CITY OF ALBUQUERQUE

May 28, 2021

**Re: Buglo Apartments - 5530 Buglo Ave NW
Erosion and Sediment Control Plan
Engineer's Stamp Date 5/26/2021 (K19E108)**

TEMPORARY EROSION AND SEDIMENT CONTROL PLAN

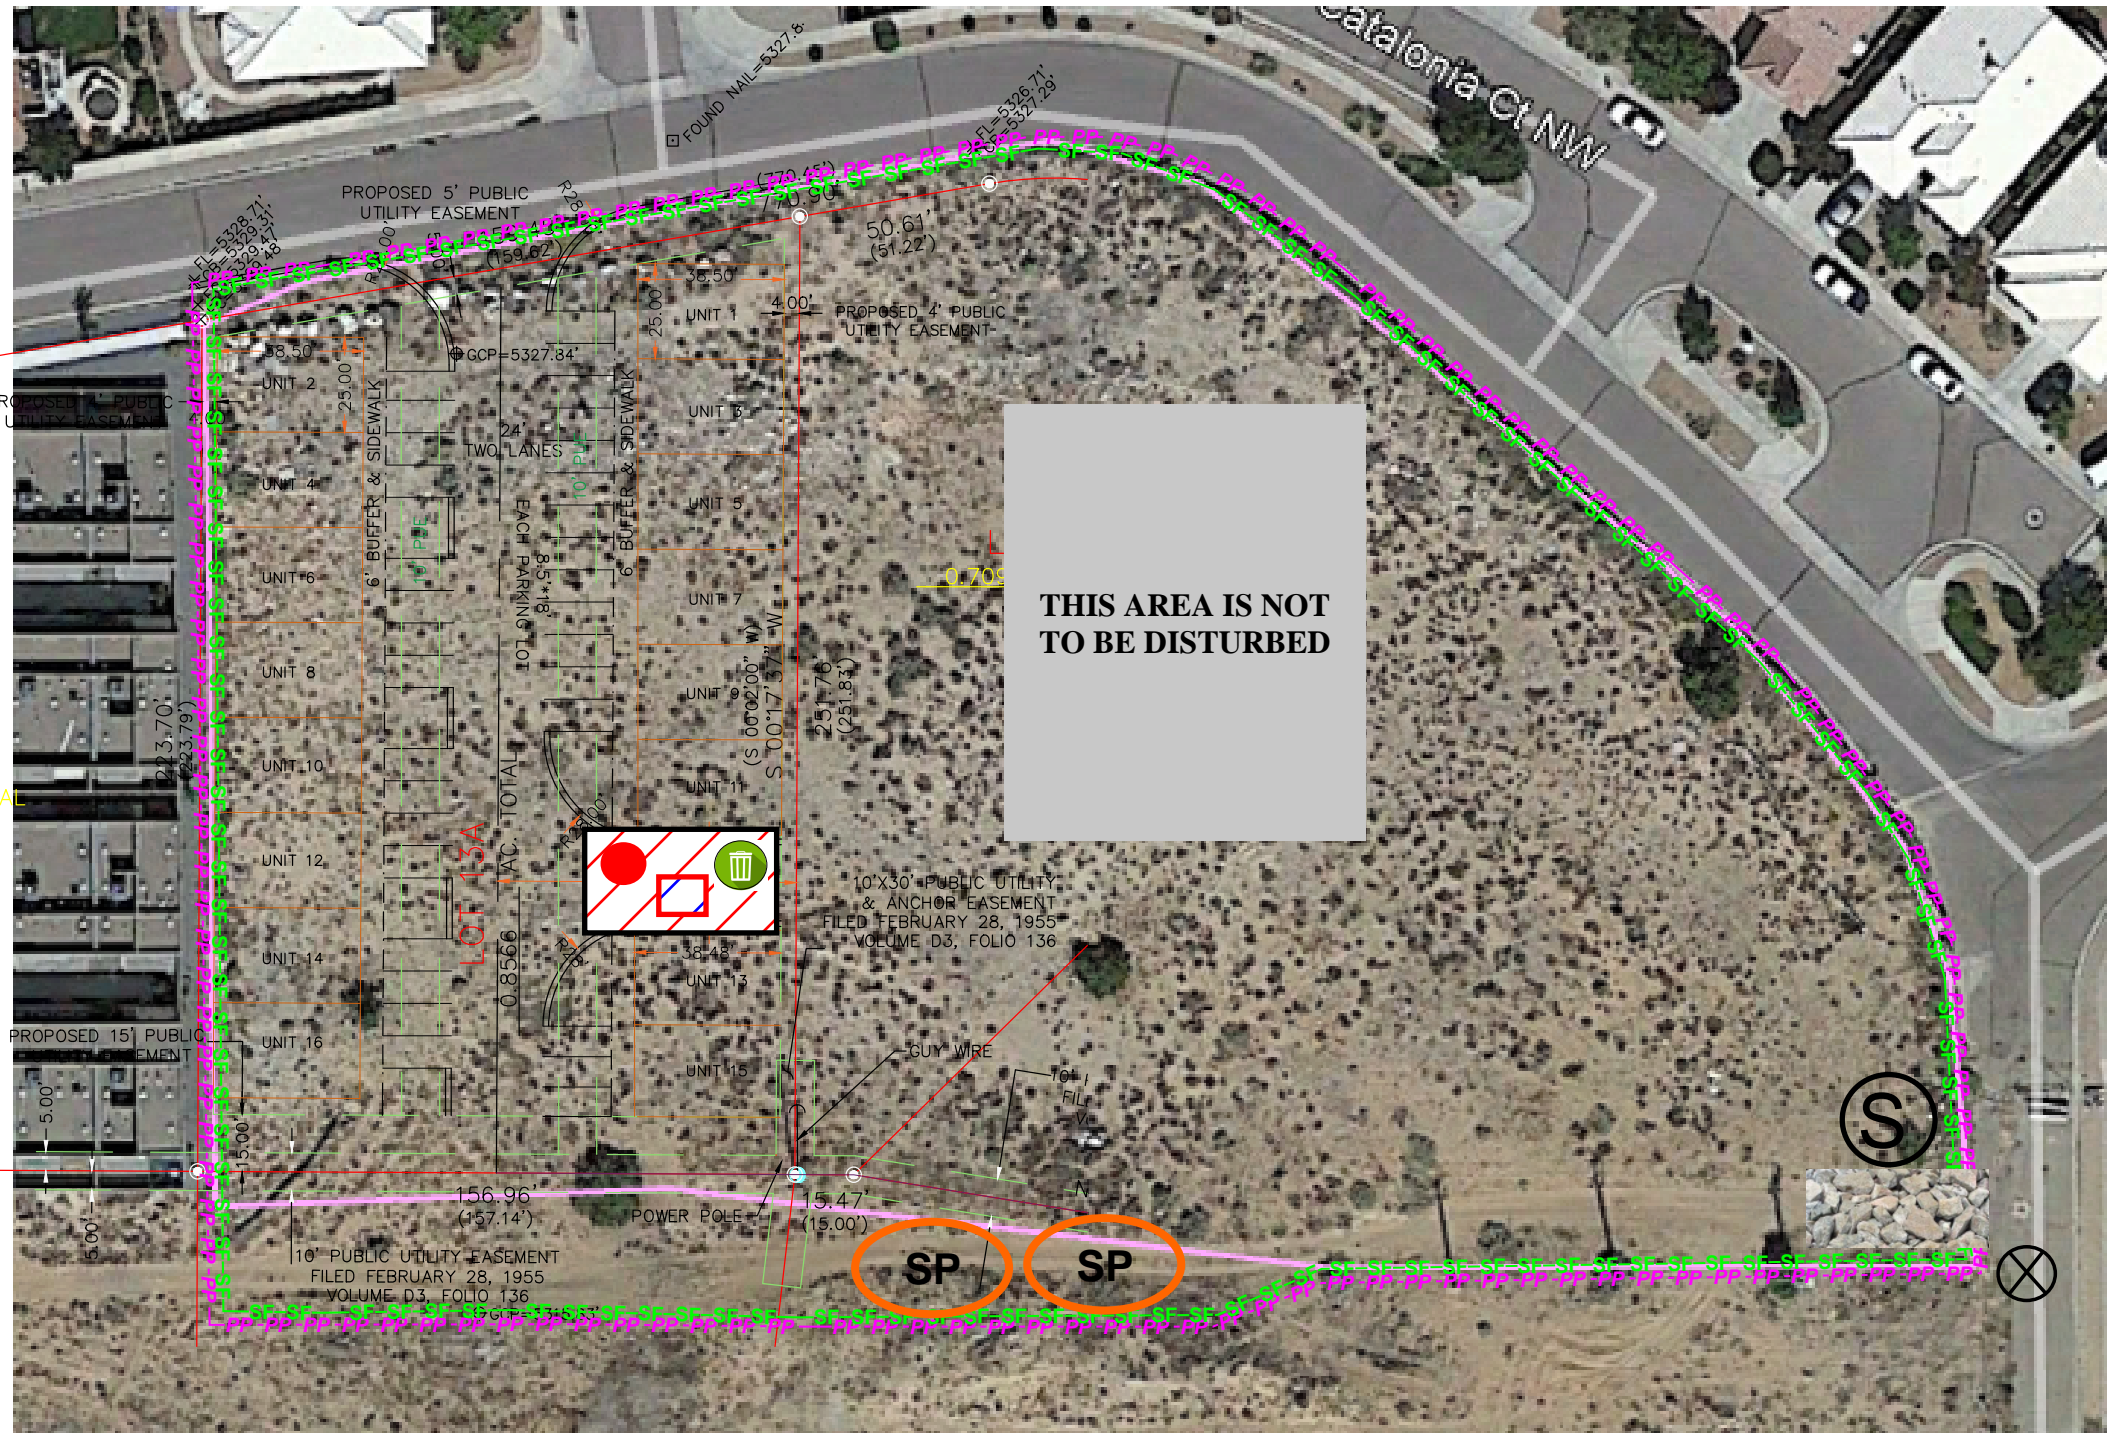
1. The plan must be updated using the approved G&D Plan as a base. The existing and proposed grades must be shown on the plan. (CGP7.2.4.b.ii);
2. The limits of disturbance must be shown and include the disturbance on the adjacent properties. Show the staging and stockpile areas adjacent to the proposed apartments.

STABILIZATION PLAN

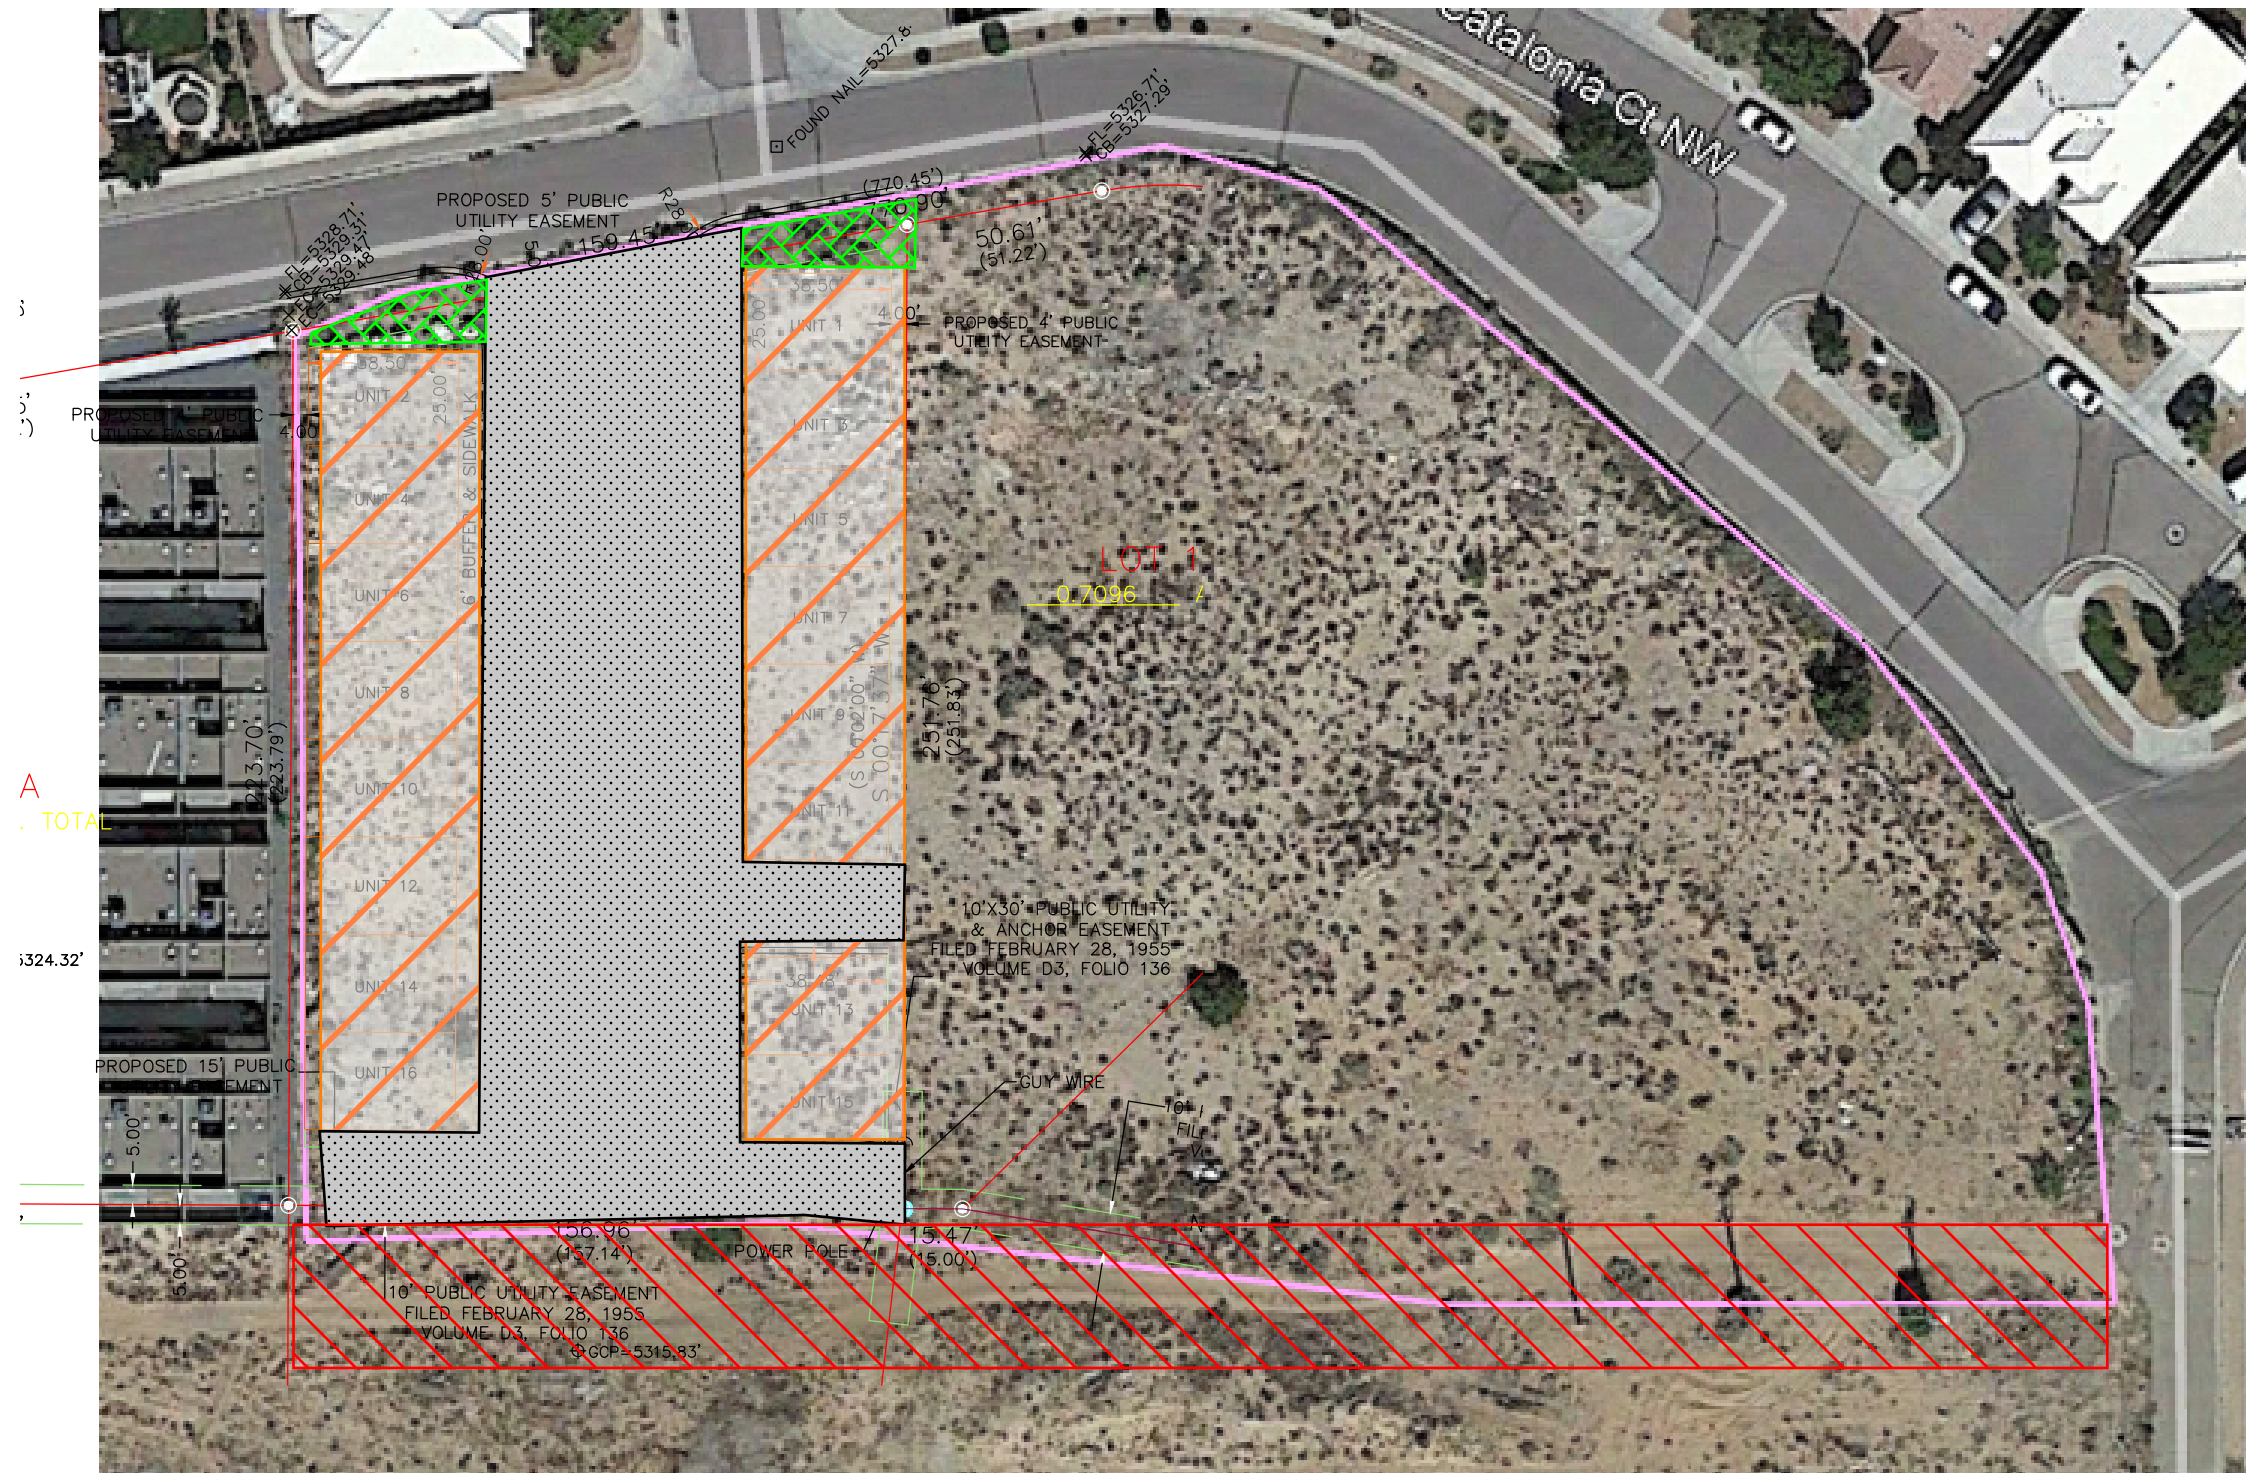
3. Identify Final Stabilization measures for those and include specifications such as Native Seed and Aggregate Mulch per City Standard Specification 1012. The Hydromulch shown on sheet 5 doesn't satisfy the Final Stabilization Criteria.
